Comment #	Page Number	Commenter	Agency	Comment	Action Taken
1		Curtis Cherne	COA	Turning counts showed few pedestrians at Gonzales Rd and Bataan Dr. Were students observed walking across Gonzales Rd at another location?	The only multimodal operations that were observed were from the TMC counts.
2		Curtis Cherne	COA	In Site Recommendations, where is the pedestrian crossing across Gonzales Rd to be located?	the site plan has been updated with the proposed crossing location
3		Curtis Cherne	COA	For the Site recommendation for right-in operations lane delineators or similar will be needed. Show a proposed method for the right-in operations on the Site Plan. It should not interfere with the left-out for southbound 69th St.	the site plan has been updated with a directional median on the school's property to facilitate right-in operation.
4	0.426388889	Curtis Cherne	COA	Add an AM/PM legend to all trip/volume figures.	Added an AM/PM legend to all trip/volume figures.

Figure 1: Site Plan

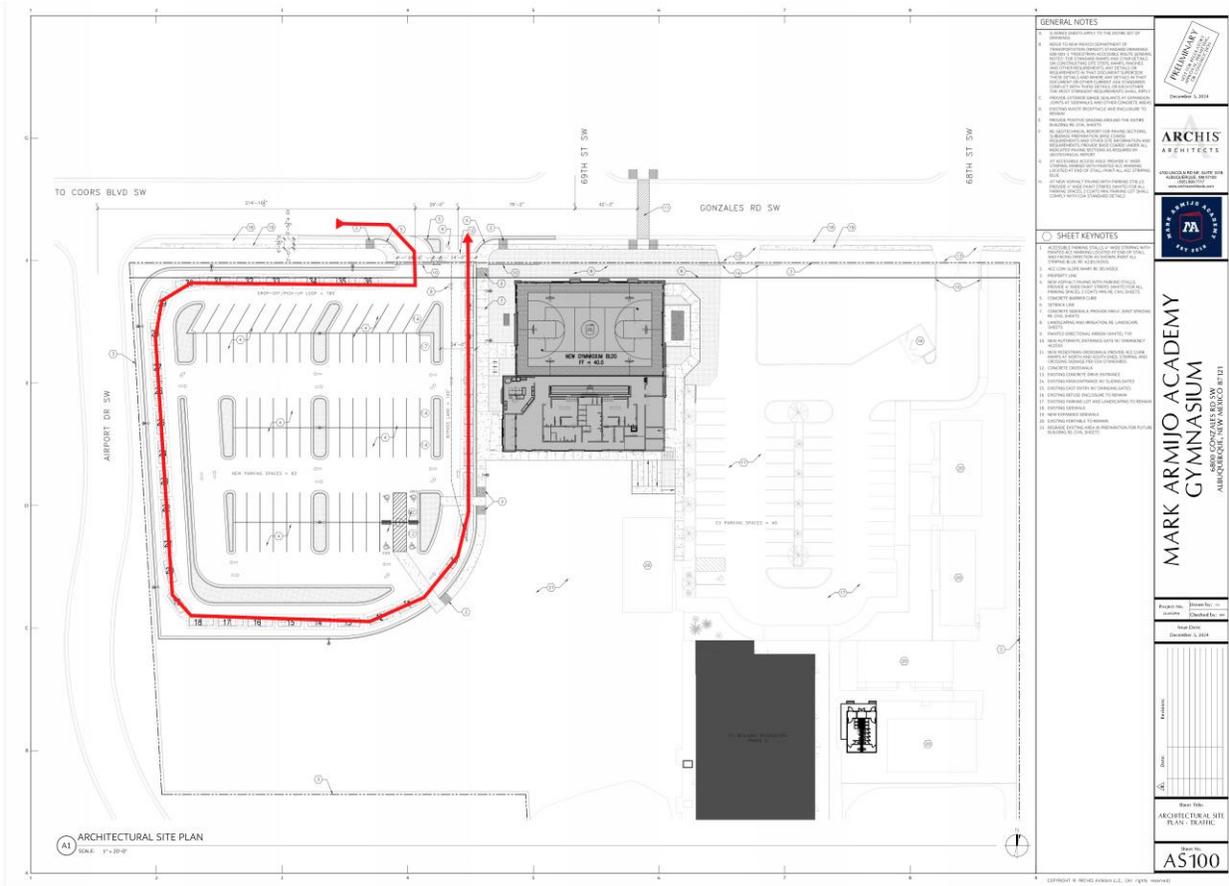
19	Page 10	Margaret Haynes	NMDOT	Figure one does not dexcribe the ingress and egress operations. Please label onFigure.	Added "Drop/off/pick-up traffic will enter the development via a right turn from Dolores Road and exit to Dolores Road via a left or right turn" to the Project location and site plan section . Also, added a path to figure 1
20	Page 15	Margaret Haynes	NMDOT	Can you clarify what movement is Table 5? Please provide analysis of NBR at NM 45and Gonzales.	Clarified movement in table 5 and added analysis results of NBR at Coors and Gonzales
21	Page 16	Margaret Haynes	NMDOT	Also check sight distance for NBR mentioned on comment above.	
22	Page 19	Margaret Haynes	NMDOT	This is the last time I will make this comment. Failure to address this will resultin a rejection of the submittal and TIA will go to the back of the queue regardless of howmuch time has already passed. If a TIA is already in my queue it should be resubmittedimmediately.SAMM defines complaint speed change lanes as transition taper, decelerationdistance and queue storage. Accommodating the queue in the storage bay is not enough bySAMM standards.	included a Speed Change Lane - SAMM compliance section with comparison table (Table 14)

Figure 4: Site-Generated Direct Trip Routing Percentages

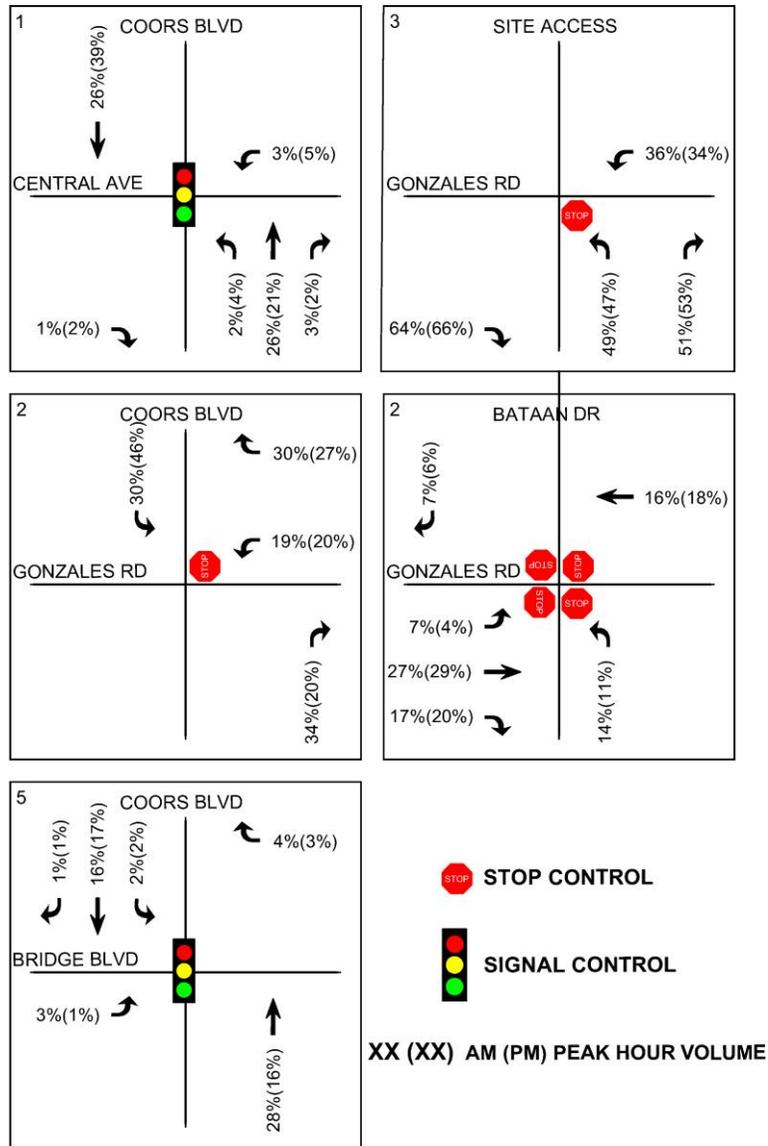
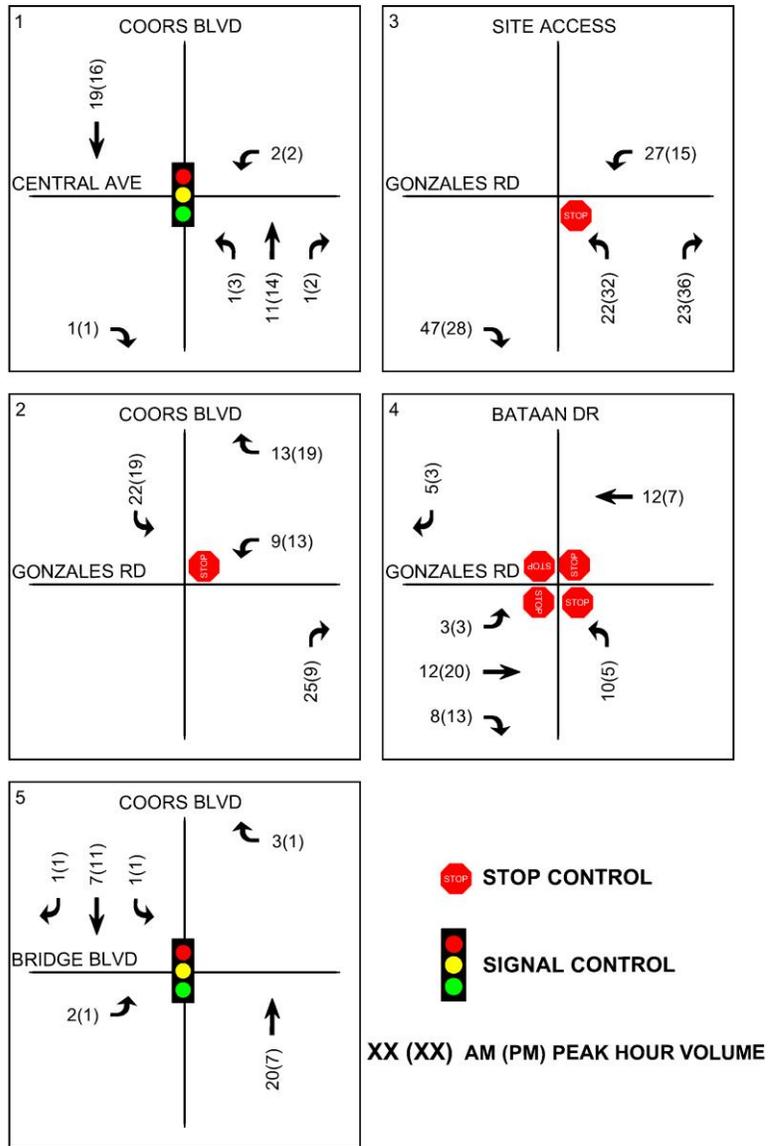
5	10	Curtis Cherne	COA	Figure 4 and Figure 5 have the same numbers for turning movements It appears Figure 4 is to be revised to show Trip Routing Percentages. Please figure out which is the trip distribution percentage and revise as necessary.	Updated trip routing figures
6		Curtis Cherne	COA	Provide a clear Site Plan that is a minimum of 11x17 inches. Site Plan to include transportation related features and dimensions rather than a grading and drainage plan as was provided with this submittal.	
7		Curtis Cherne	COA	Provide dimensions from the centerline of the proposed driveway to the: centerline of 69th St on the opposite side of Gonzales Rd and to the driveway to the community center.	Figure 1 has been updated to show these dimensions
8		Curtis Cherne	COA	Queueing onto Gonzales Rd should be prevented. Demonstrate the available vehicle queue length for the drop-off/pick-up lane on the Site Plan.	Site plan updated to show 36 vehicles on the property.
